Our ref: SSD-11826681 and SSD-11826621

Subject: Request for Additional Information - Air Quality Impact Assessment

I refer to the HVO North and HVO South Open Cut Coal Continuation Projects (SSD-11826681 and SSD-11826621) and the Air Quality Impact Assessment, dated 29 July 2025. The assessment results indicate predicted exceedances of the Department's *Voluntary Land Acquisition and Mitigation Policy (2018)* (VLAMP) annual cumulative PM₁₀ and PM_{2.5} and deposited dust criteria.

Figure 39 Modelled maximum extent of VLAMP criteria

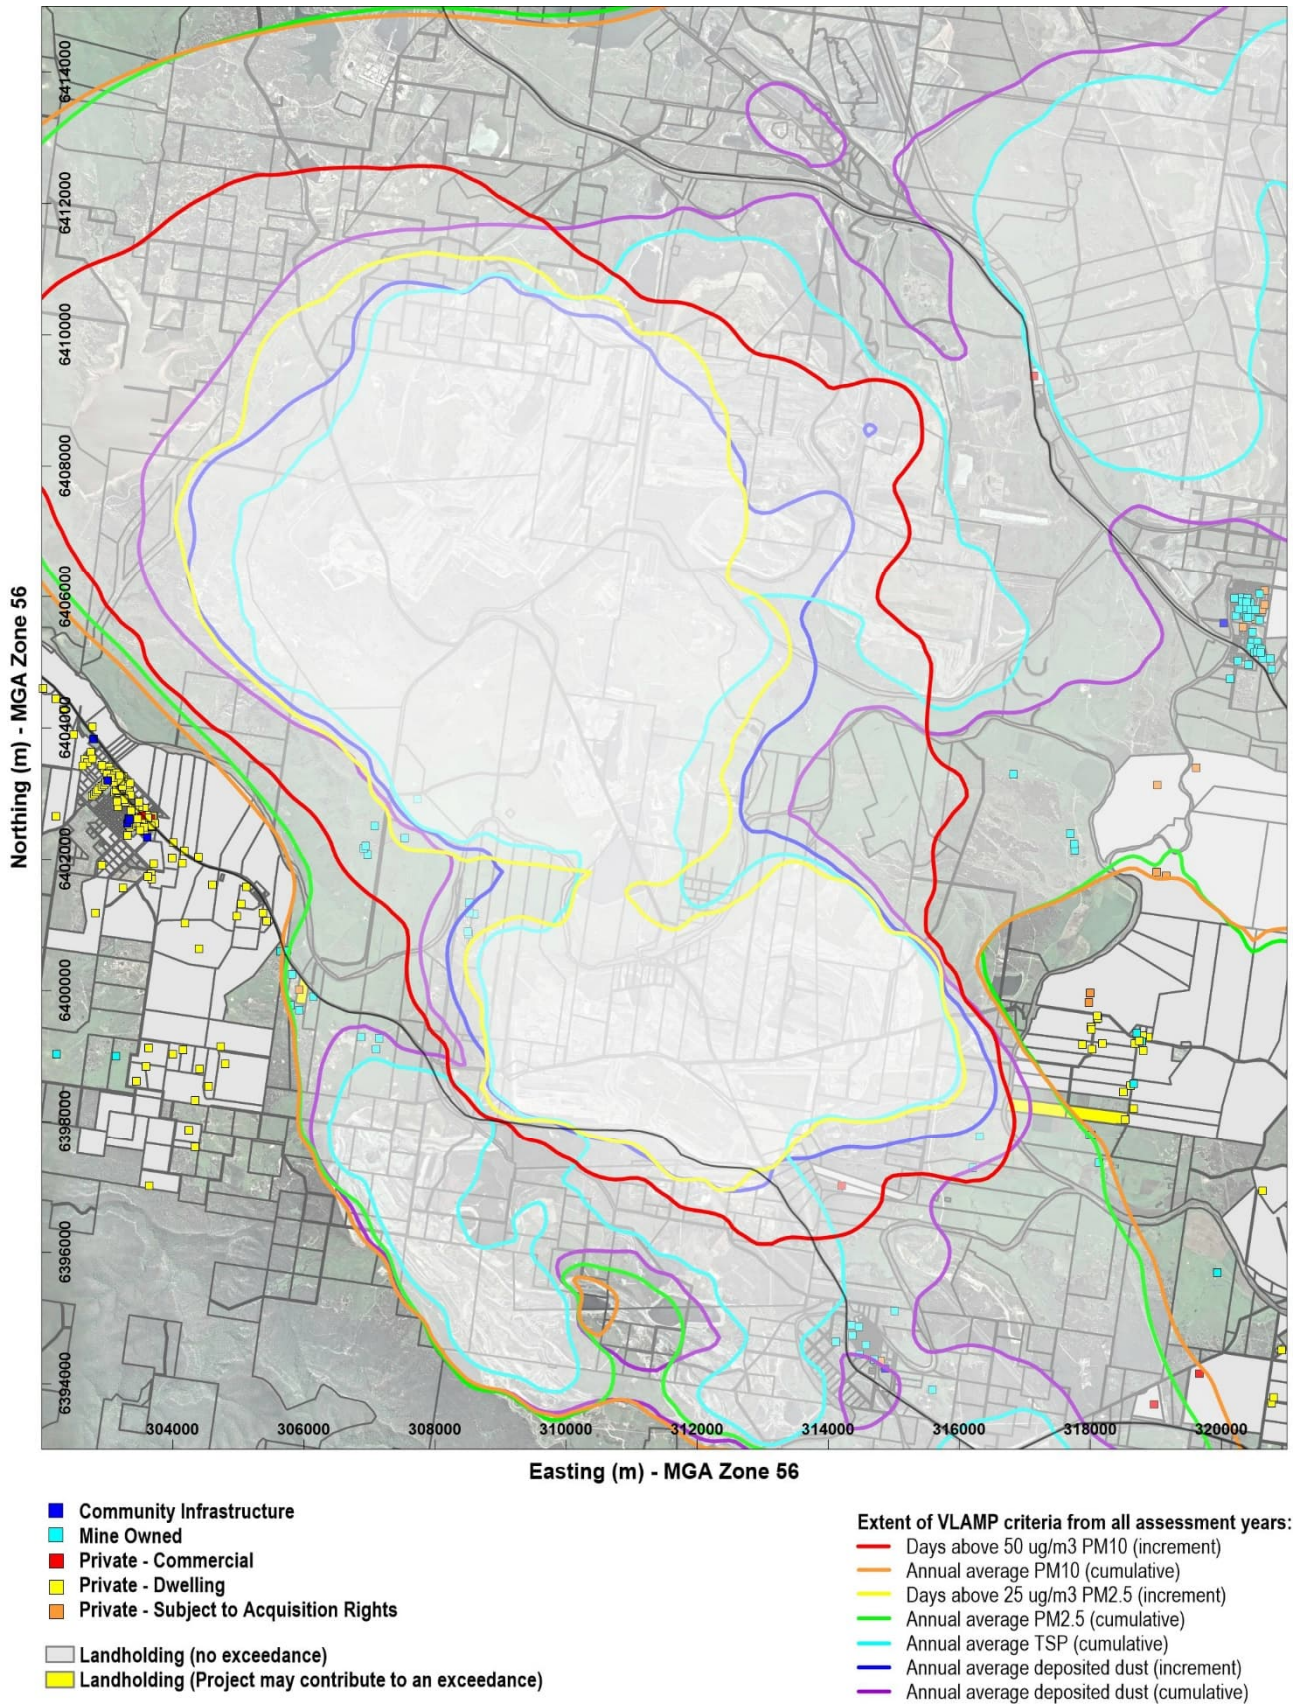
1. Annexure C of the Air Quality Impact Assessment (dated 29 July 2025) shows predicted exceedances of the VLAMP annual cumulative PM₁₀ and PM_{2.5} criteria at private receptors (621, 624, 626, 627, 628, 860, 861, 862, 863, 102 and 596), private commercial receptors (830 and 833) and community infrastructure (264). Further information is required to demonstrate how the VLAMP has been considered for the exceedances shown in Annexure C and how the predicted exceedances are influenced by project contributions and average background concentrations. You are requested to:

- a. Demonstrate how the provisions of the VLAMP have been considered for the predicted exceedances of the VLAMP criteria; and
 - b. Provide a table listing receptors (ranked by the highest predicted cumulative impacts) that exceed the VLAMP annual cumulative PM_{10} and $PM_{2.5}$ criteria ($25 \mu\text{g}/\text{m}^3$ and $8 \mu\text{g}/\text{m}^3$). List the average background concentrations for each and HVO's contribution to these exceedances.

3. Annexure C of the Air Quality Impact Assessment (dated 29 July 2025) shows exceedances of the VLAMP's annual cumulative deposited dust criteria at private receptors (102, 592, 596, 619, 621, 624, 626, 627, 628, 629, 860, 861, 862, 863) and community infrastructure (264,507, and 511). You are requested to demonstrate how the provisions of the VLAMP have been considered for the predicted exceedances shown in Annexure C.
